## Notes of 2/15 MMC Site Plan Review Meeting (CMP/Detours)

Key points from the 2/15/18 Site Plan Review meeting with MMC:

### **Congress Street Closure and associated detours/emergency access (based on the revised docs and plans attached to this e-mail from Gorrill-Palmer)**

**CMP - East Tower and Visitor Garage (based on revised CMP as attached from Turners)**

SEE TURNER LOGISTICS PLAN FOR  
BLOW UP OF STEEL DELIVERIES AT SITE

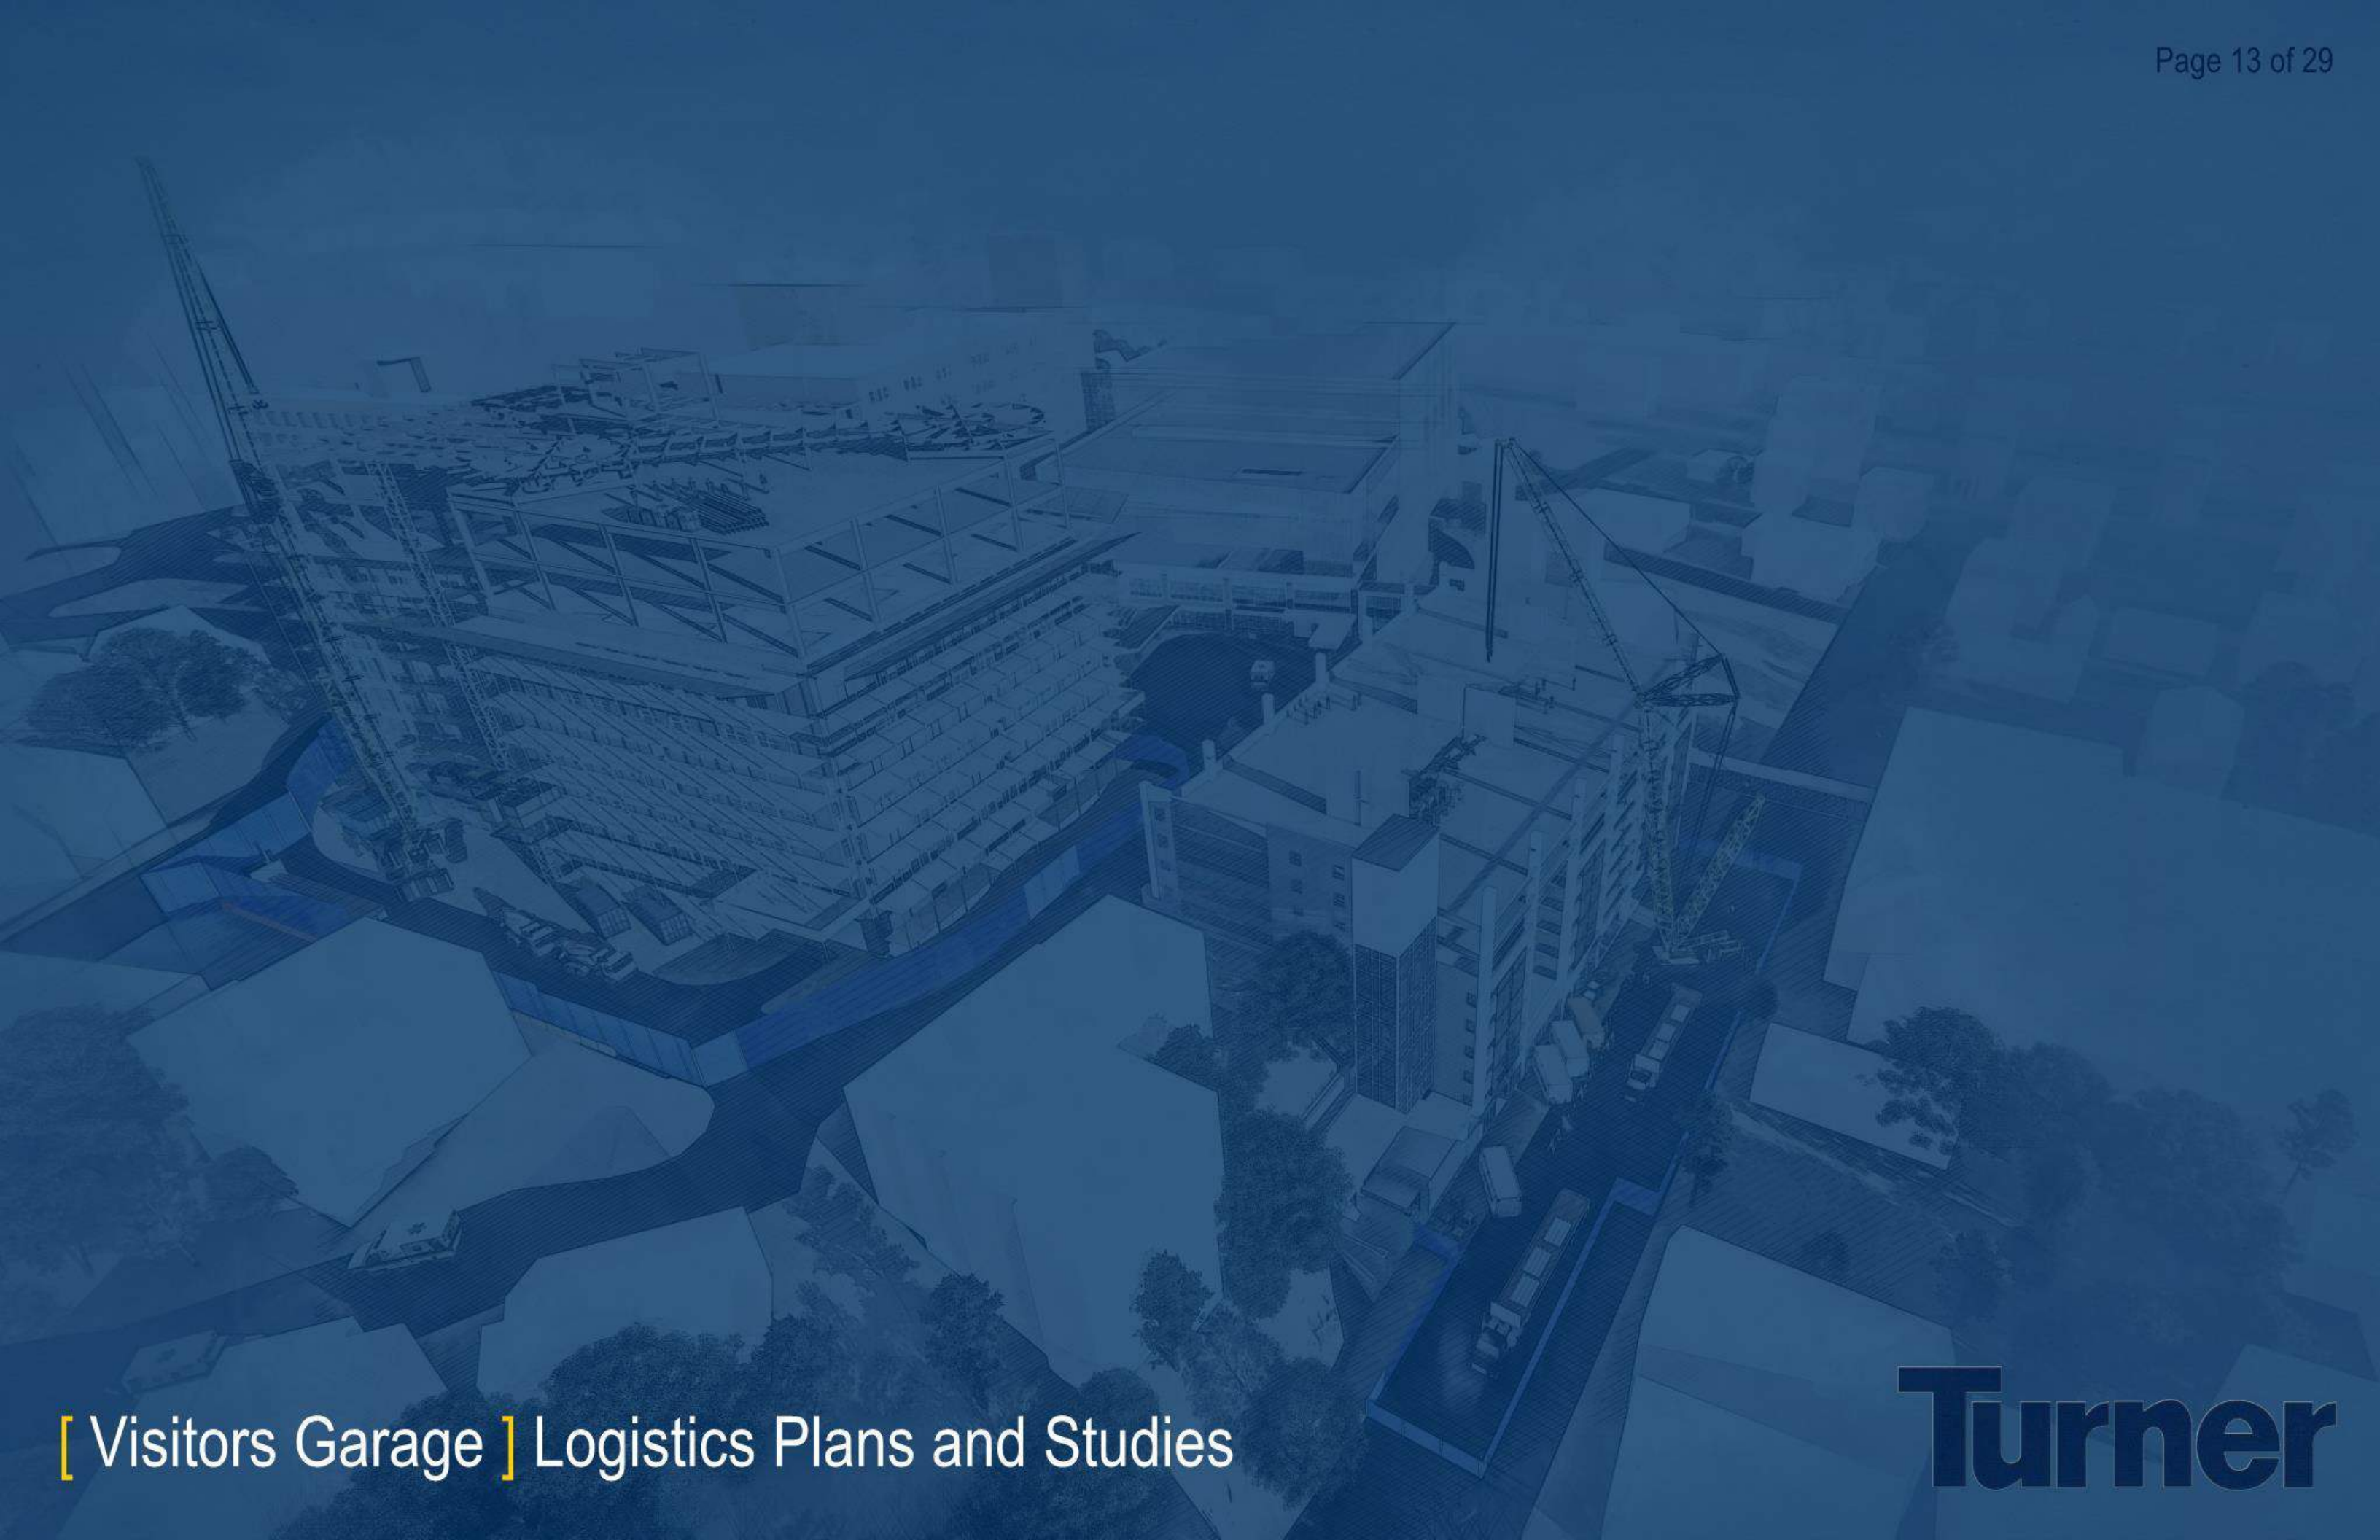
- Reviewers questioned the proposal to route steel deliveries (from North, June 4 to June 28, starting at 5am) along Washington Ave and Congress
  - City staff advised route should avoid Washington completely due to planned construction work

- Route must avoid downtown Portland and Congress
  - Keep delivery vehicles on I295 longer - maybe I295 to Forest /Park ? Deering; maybe Fore River Parkway

- Turners will speak to the trucking company again and get back to us
- Police stressed need for ongoing monitoring and process for making changes to delivery and detour routes after closure starts
